Your ref: SSD91539707

MIXED USE DEVELOPMENT AT 19A 21 GORDON STREET, COFFS HARBOUR - SSD91539707

I refer to the above-mentioned application and request for comments from the City of Coffs Harbour Council (City).

DRAWING TITLE:
A03 - GENERAL ARRANGEMENT PLANS
GROUND FLOOR

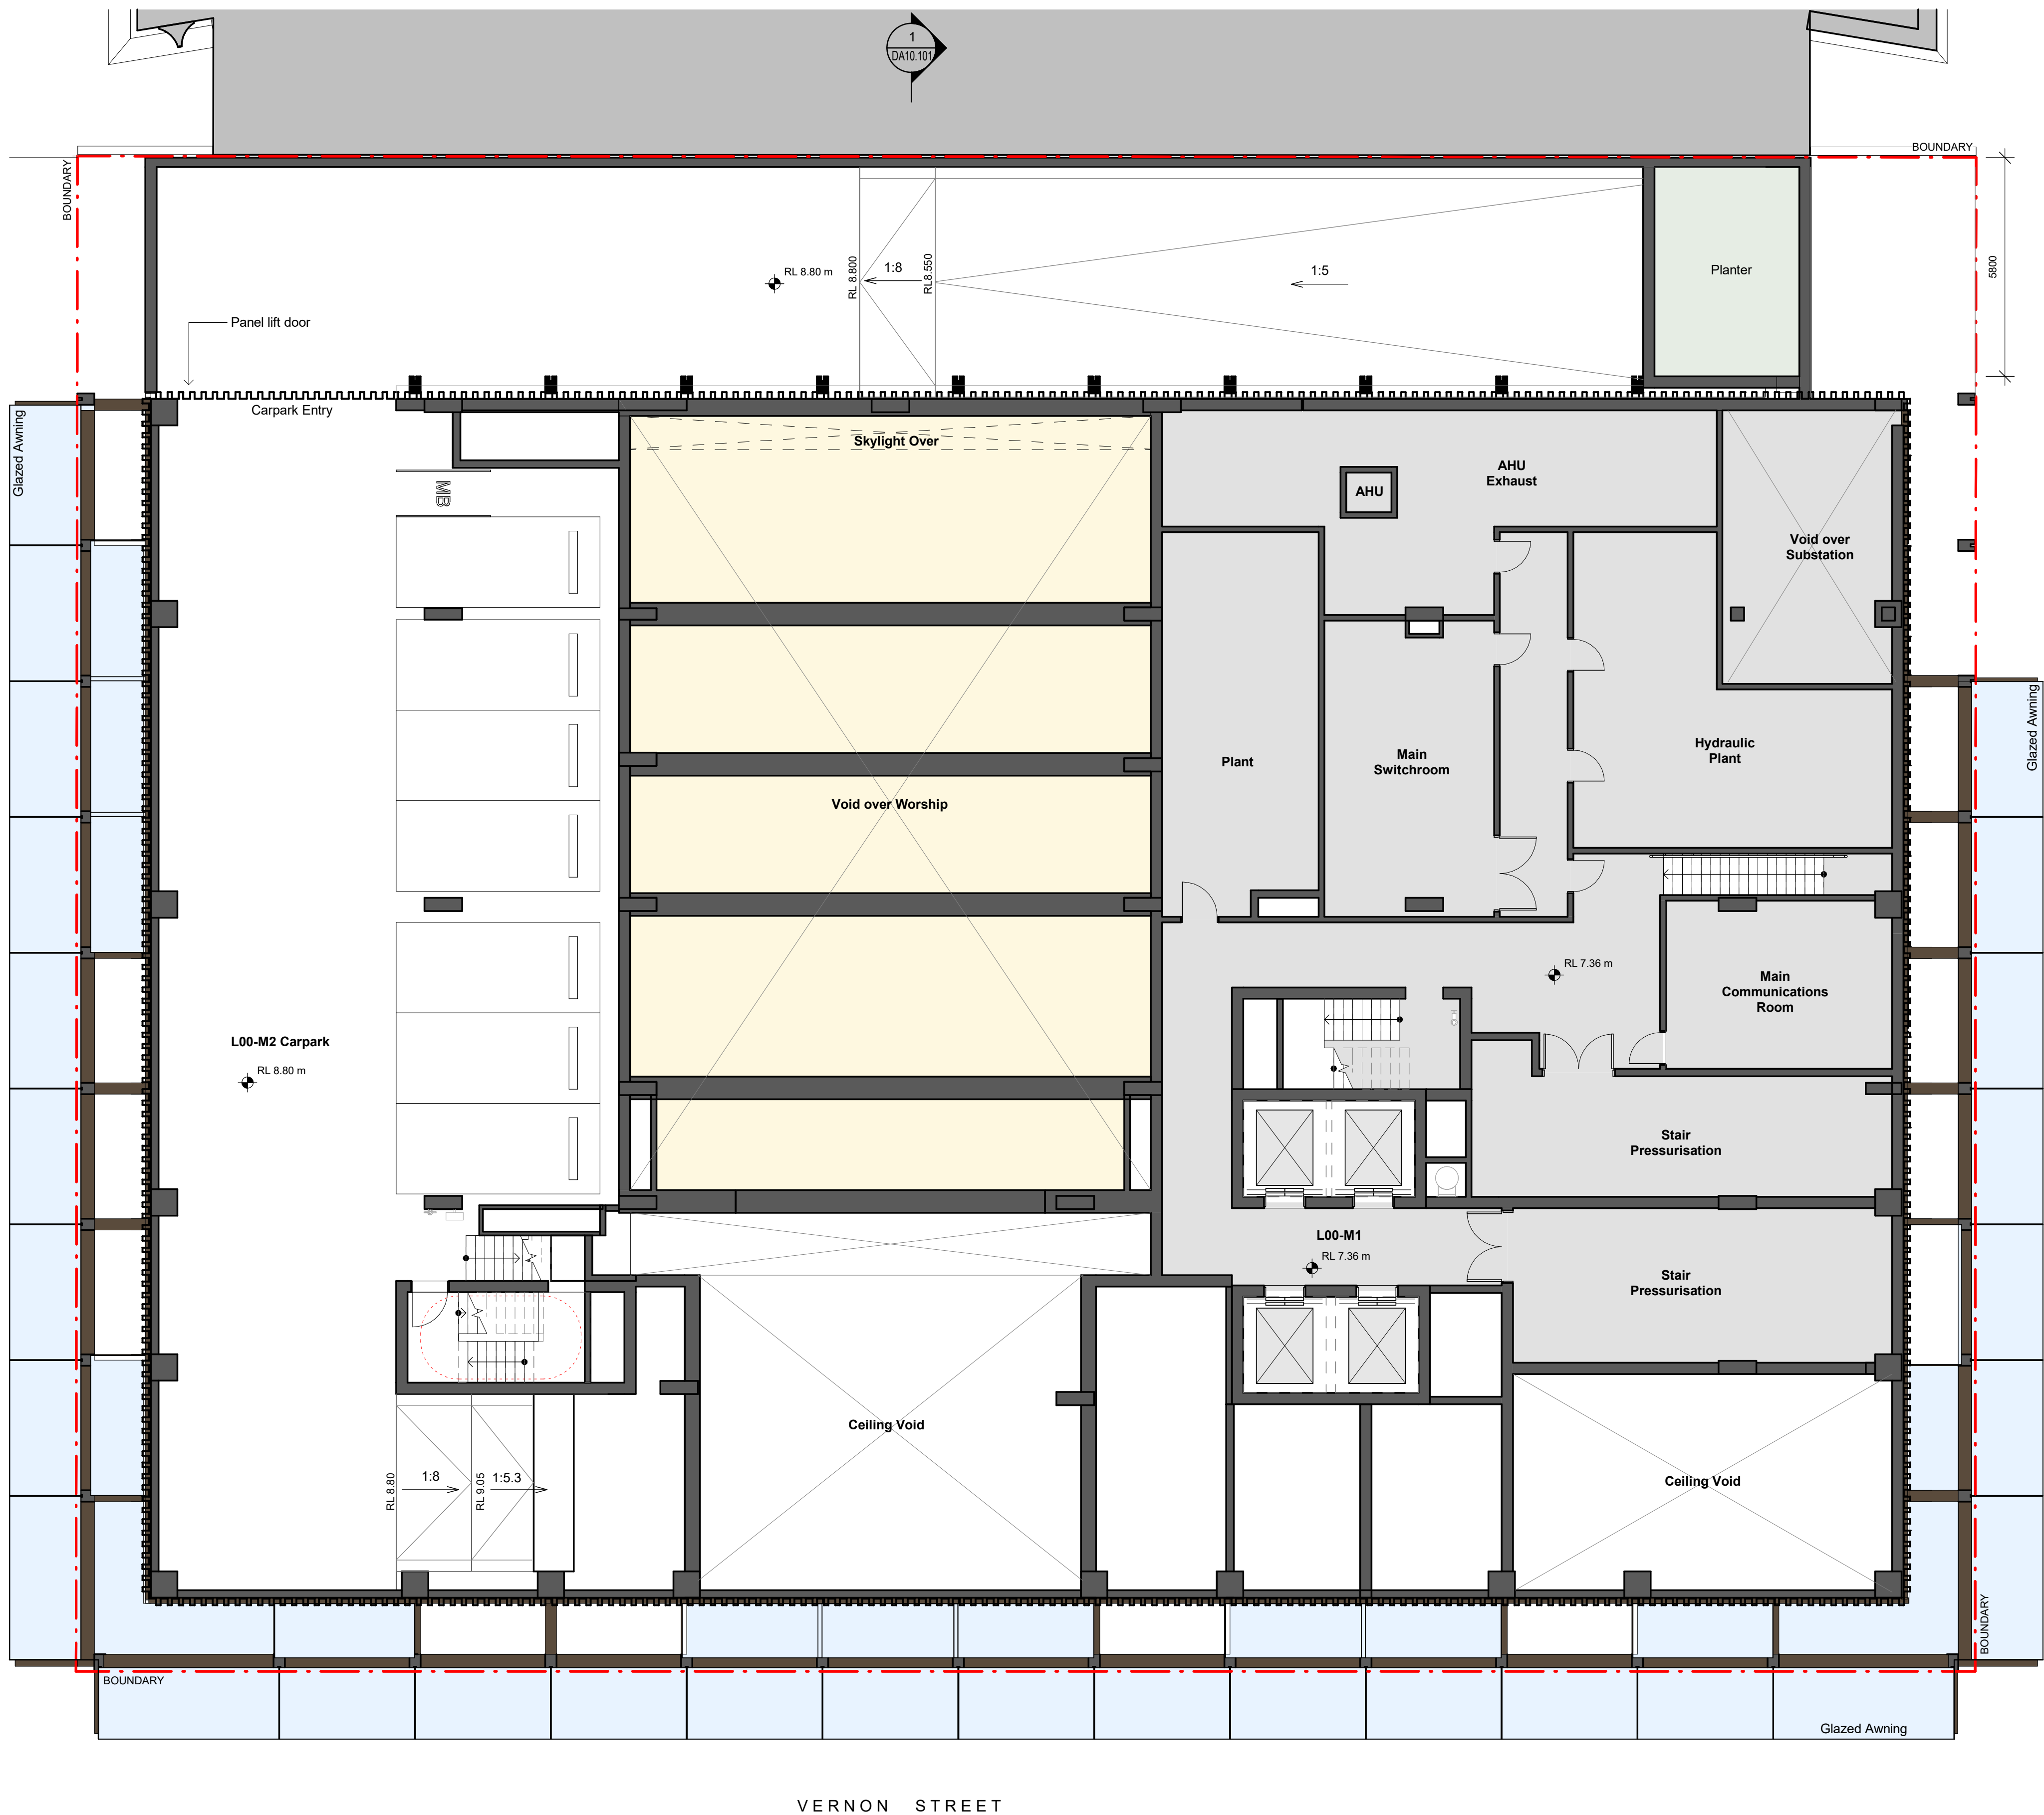
The proposed Floor Space Ratio of 8:1 cannot be verified based on the information provided. A review of the submitted plans indicates that a number of areas appear to have been excluded from the Gross Floor Area calculations, including but not limited to the ground floor hallway, waste and storage areas, and various mezzanine spaces.

A21 - AREA CALCULATION
GROSS FLOOR AREA DIAGRAM

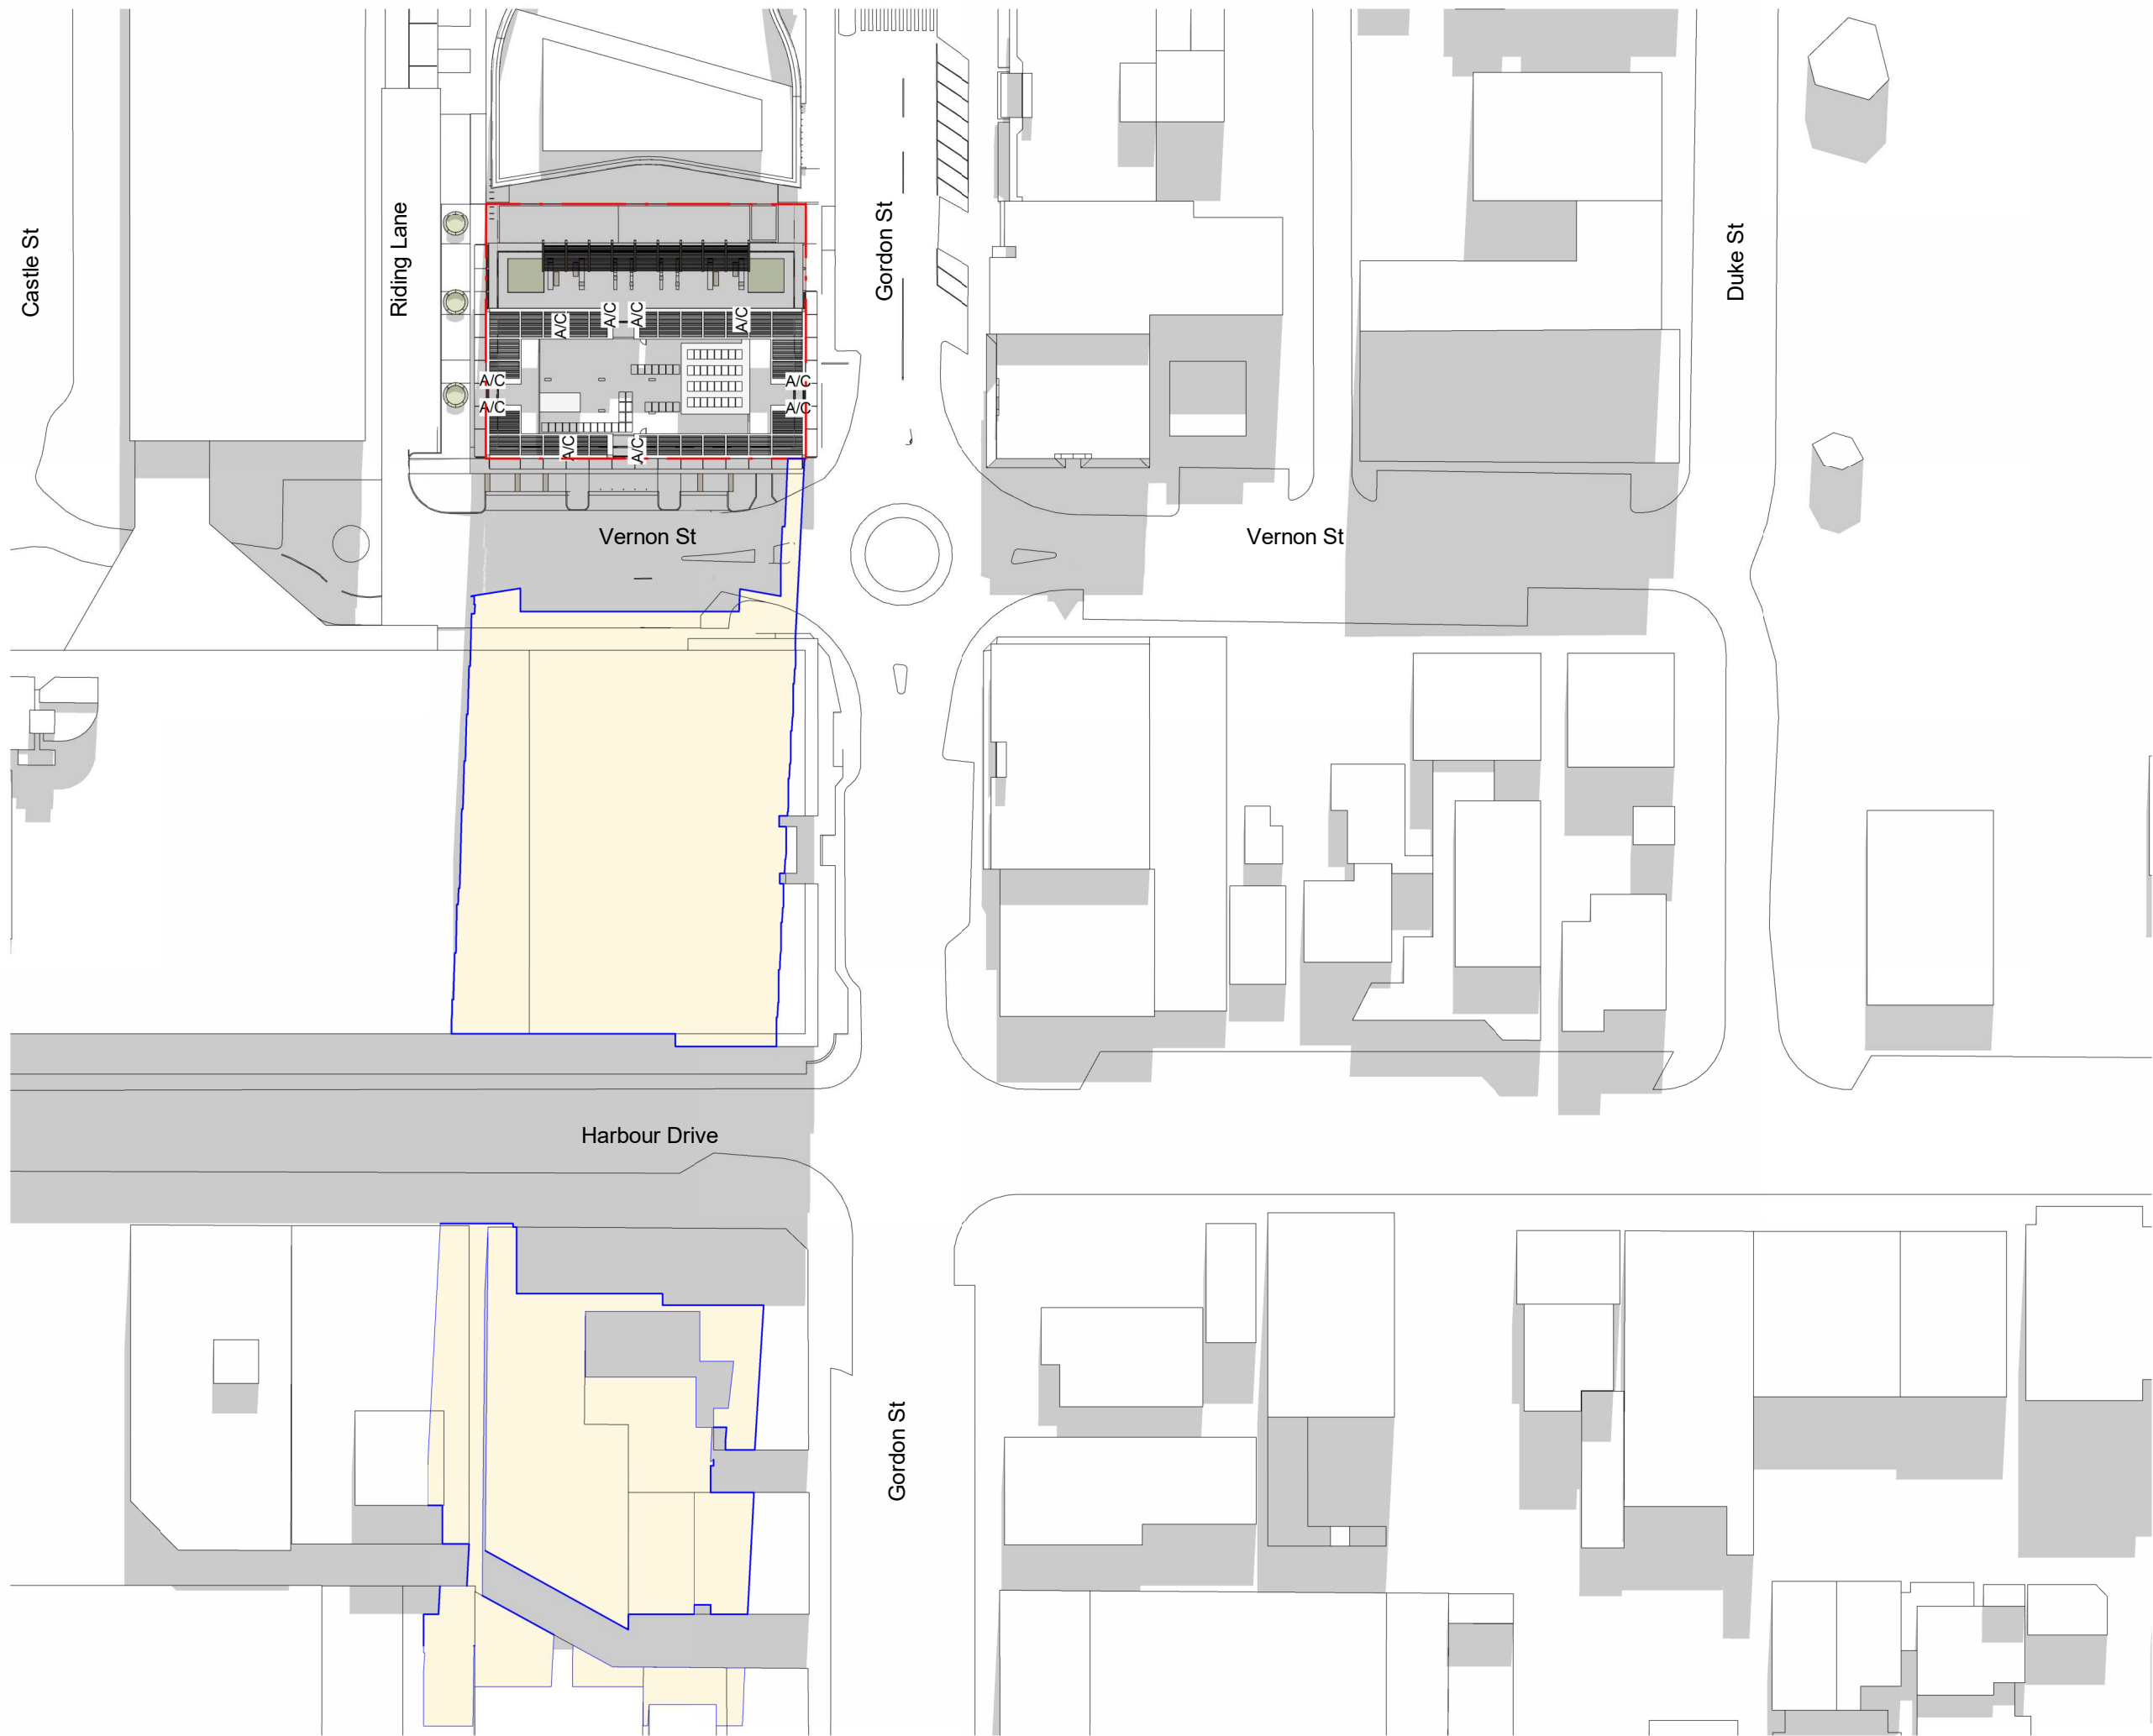
Should these areas be required to be included within the GFA under the relevant planning controls, the development may exceed the proposed FSR of 8:1 and result in a further departure to the current 4.5:1 standard. As such, further justification and detailed floor space calculations are required to demonstrate compliance with the applicable FSR standard.

A03 - GENERAL ARRANGEMENT PLANS
LEVEL 7-10 (AFFORDABLE HOUSING
LAYOUT)

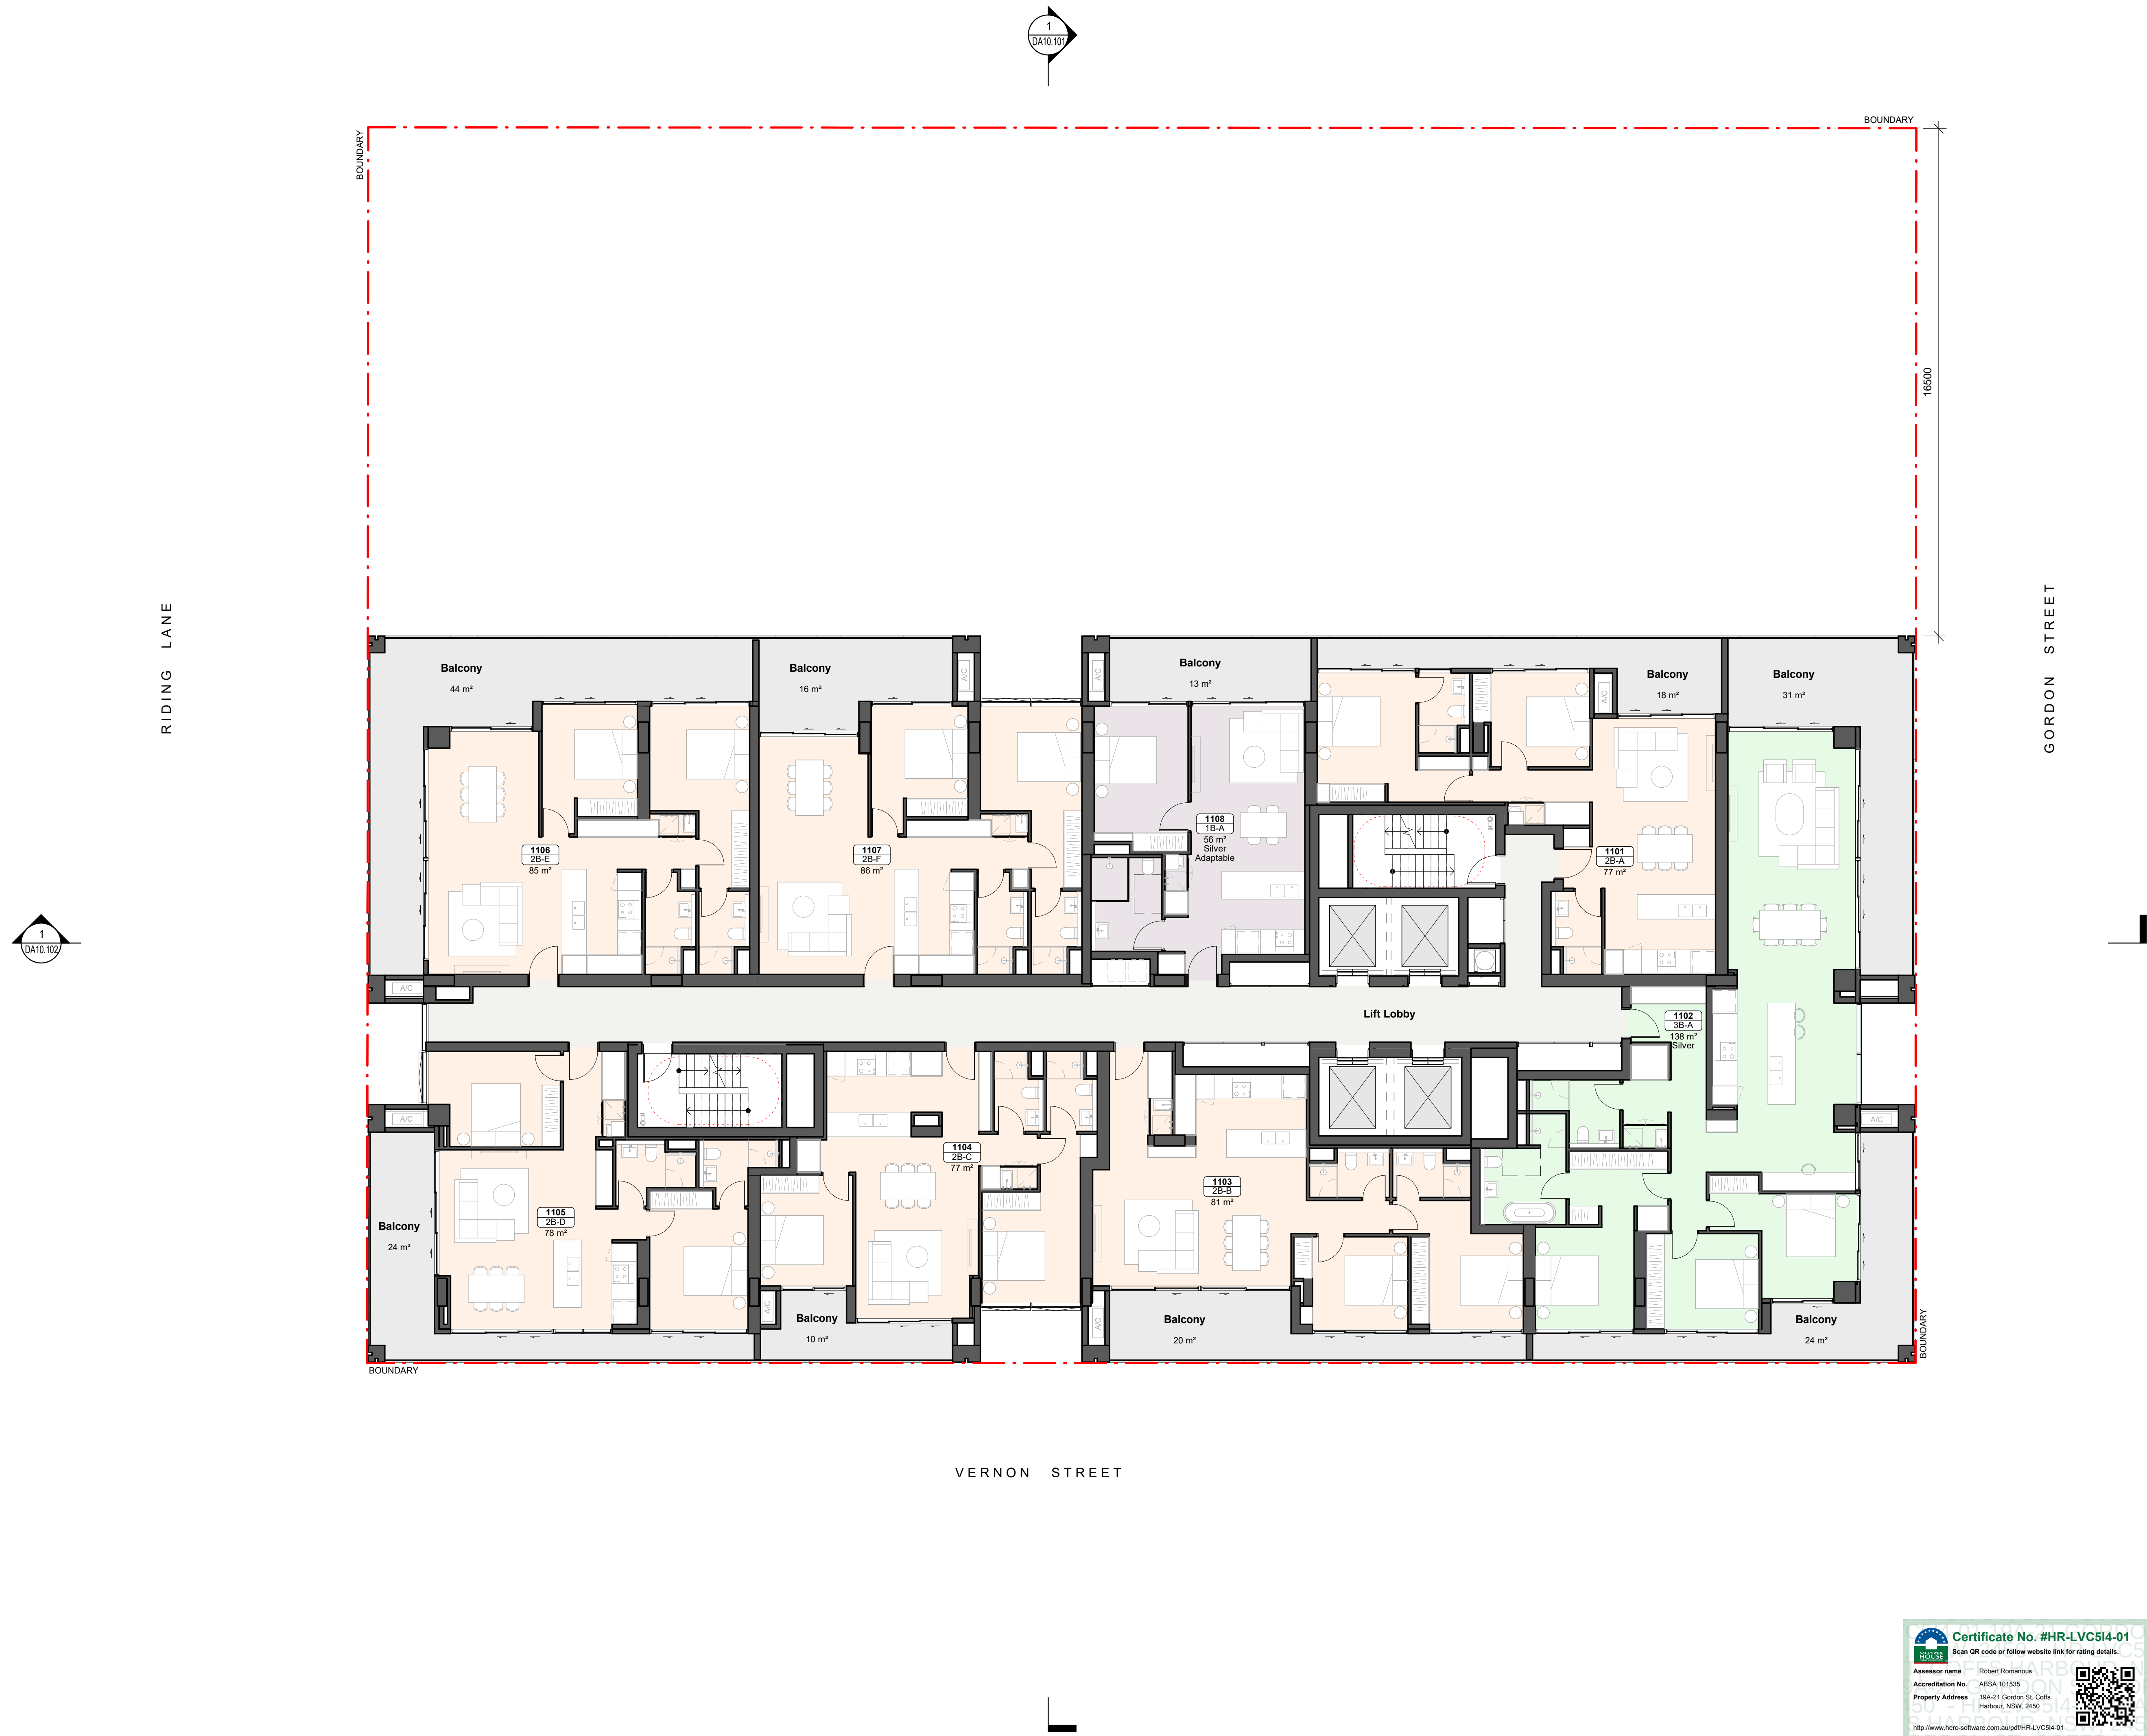
Objective 4F-1 requires that the maximum number of apartments off a circulation core on a single level is limited to 8. Levels 7-10 have 10 apartments per floor reducing the amenity of the affordable housing component.
